**From:** alan.story@hertfordshire.gov.uk  
**Sent:** 15 July 2015 15:44  
**To:** Planning  
**Subject:** Planning application S6/2015/1061/MA - Plot 6000 Hatfield Business Park

**Response to Planning application from Hertfordshire County Council (T and CP GDP Order 2015)**

**District ref:** S6/2015/1061/MA  
**HCC ref:** WH/161/2015 (Amended)  
**HCC received:** 15/07/2015  
**Area manager:** James Dale  
**Case officer:** Alan Story

Erection of a private healthcare facility (use Class C2), to include car/cycle parking, boundary treatment, landscaping, lighting and access

drawing number: 1005 PL 202
 revision: D

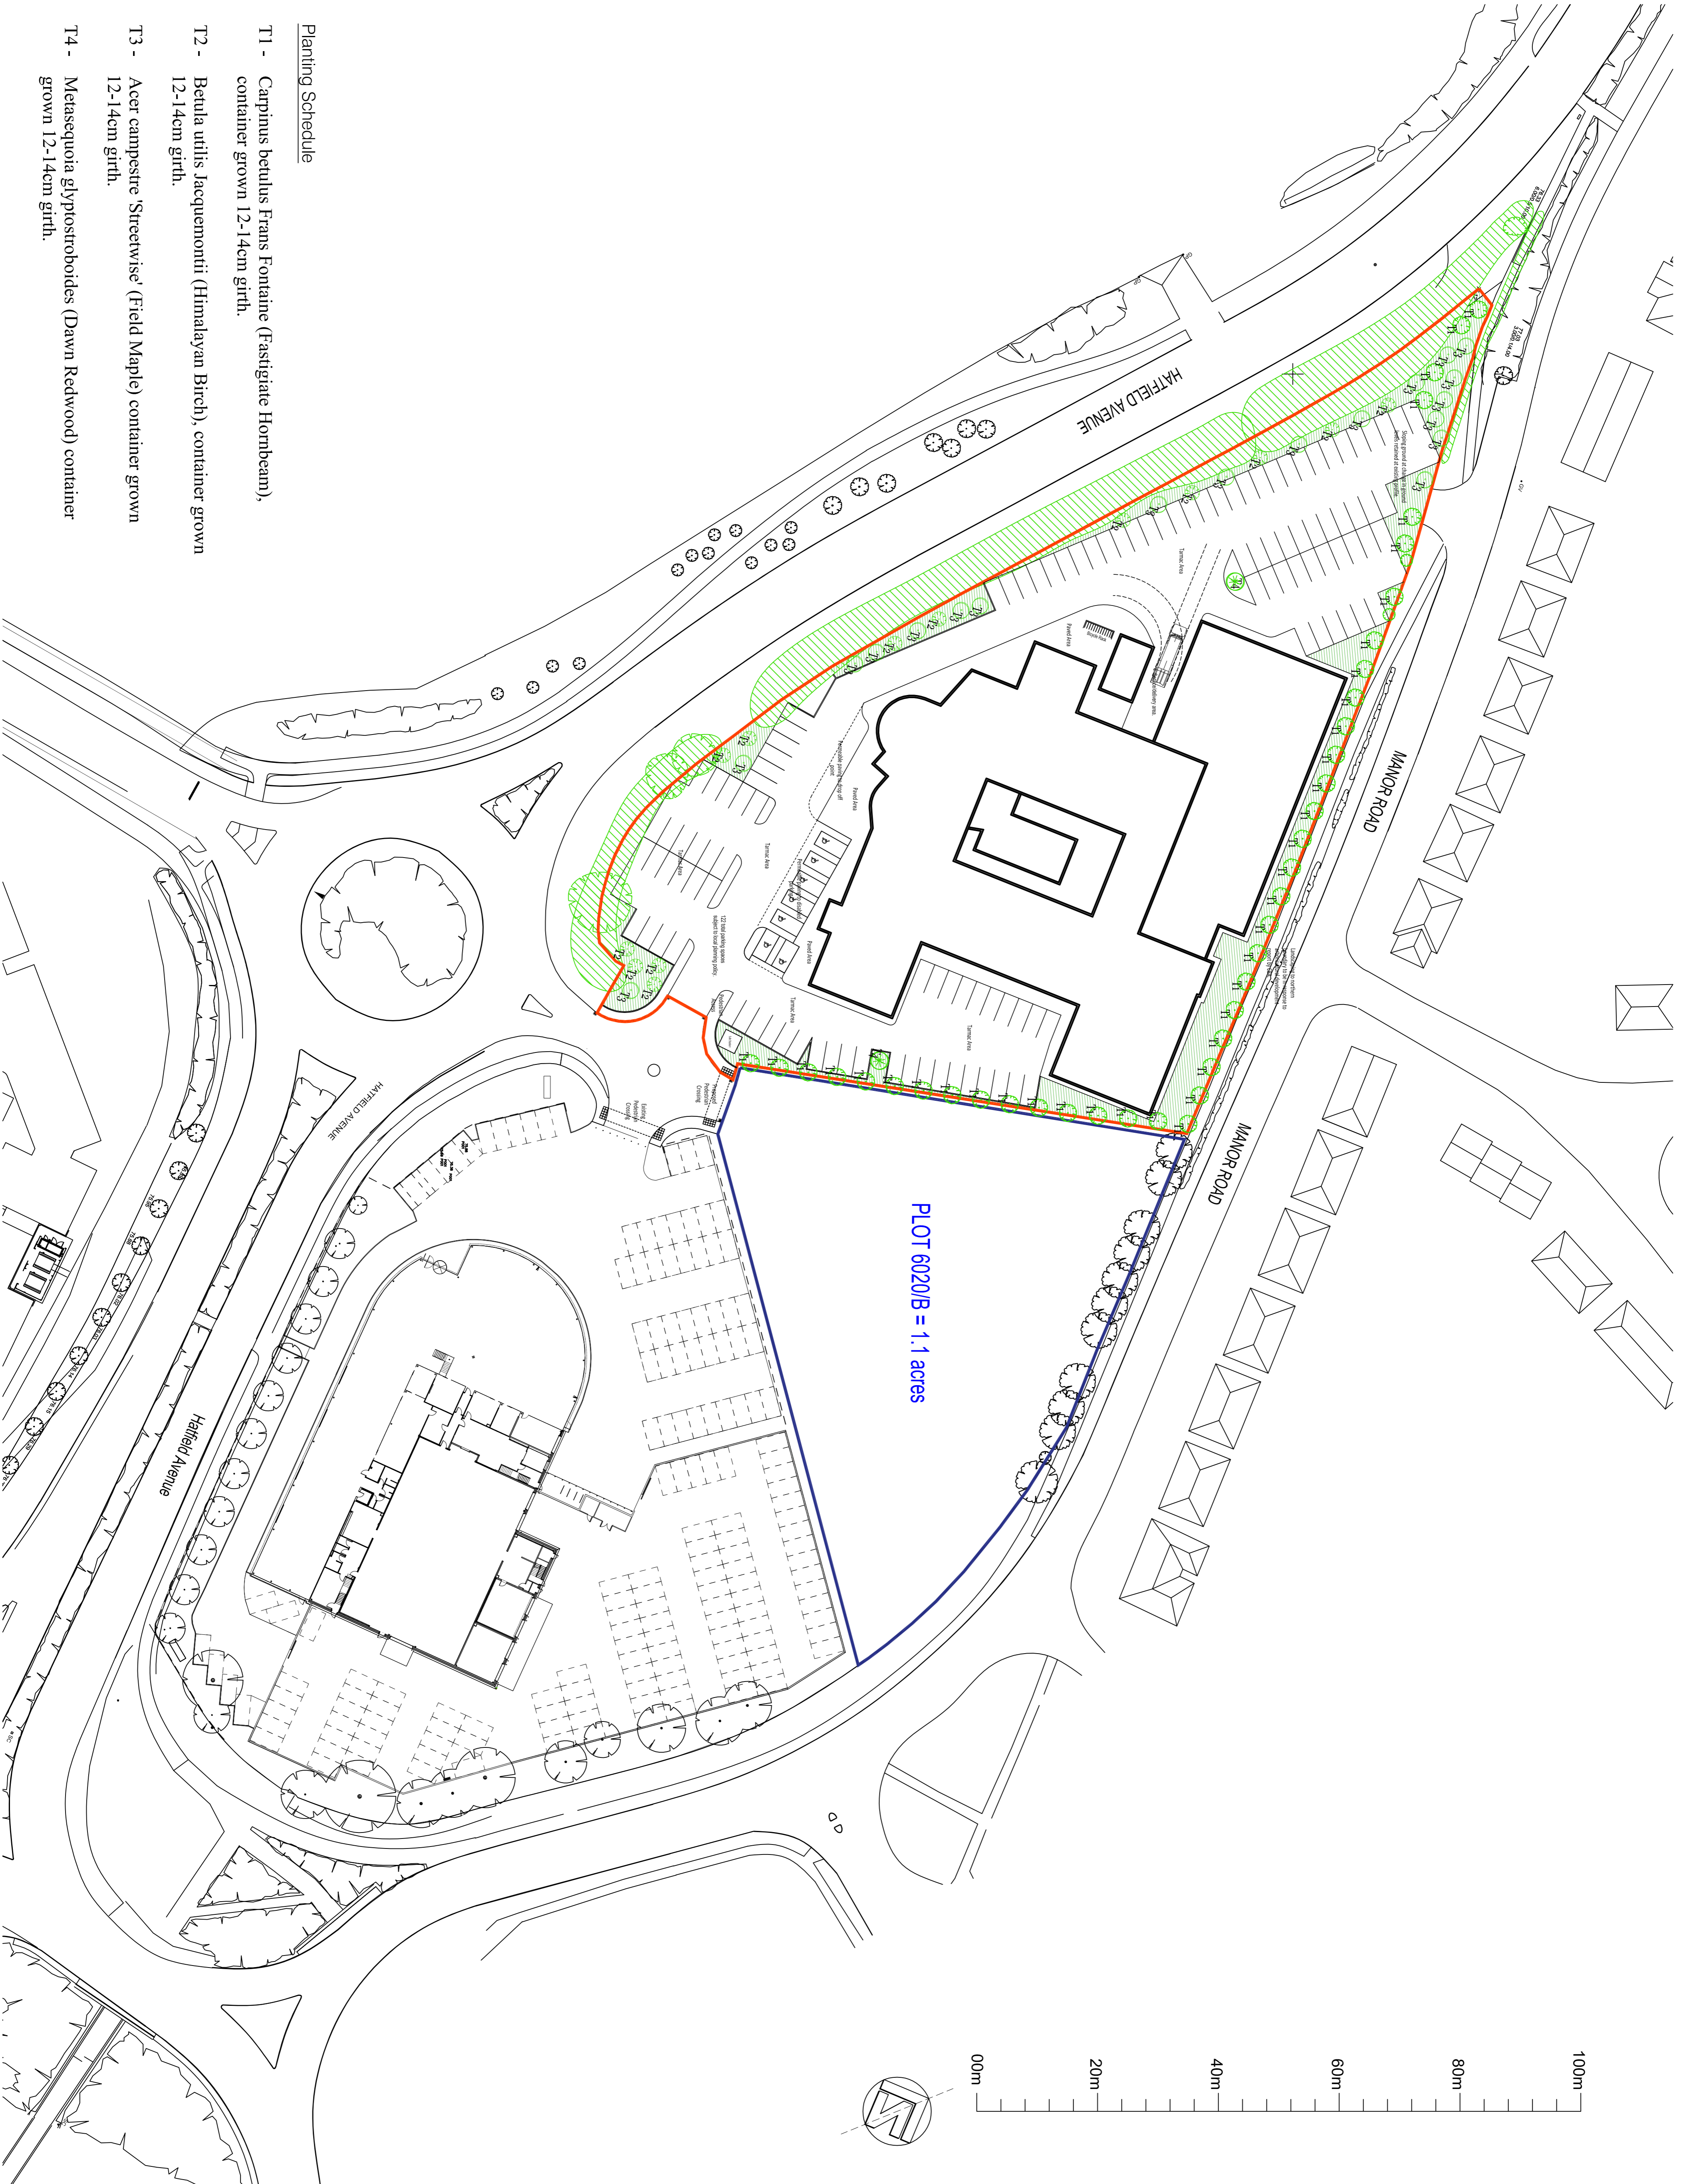
Highway Authority comments provided 07/07/2015 considered drawings 1005 PL201 Rev B and 1005 PL202 Rev B. The amended plans, each now revision C, dated 10/6/15 are identified as having been updated solely to provide disclaimer information and inclusion of scale bar.

I present confusion, as both superseded documents (rev B) were provided with scale bars, enabling the Highway Authority certainty in respect of dimensions and observations presented within our earlier comments. I can see no other material change to the scheme layout.

I therefore present that the amended drawings have no material impact on my earlier comments, but that references to drawing numbers within my earlier comments shall be varied as appropriate.
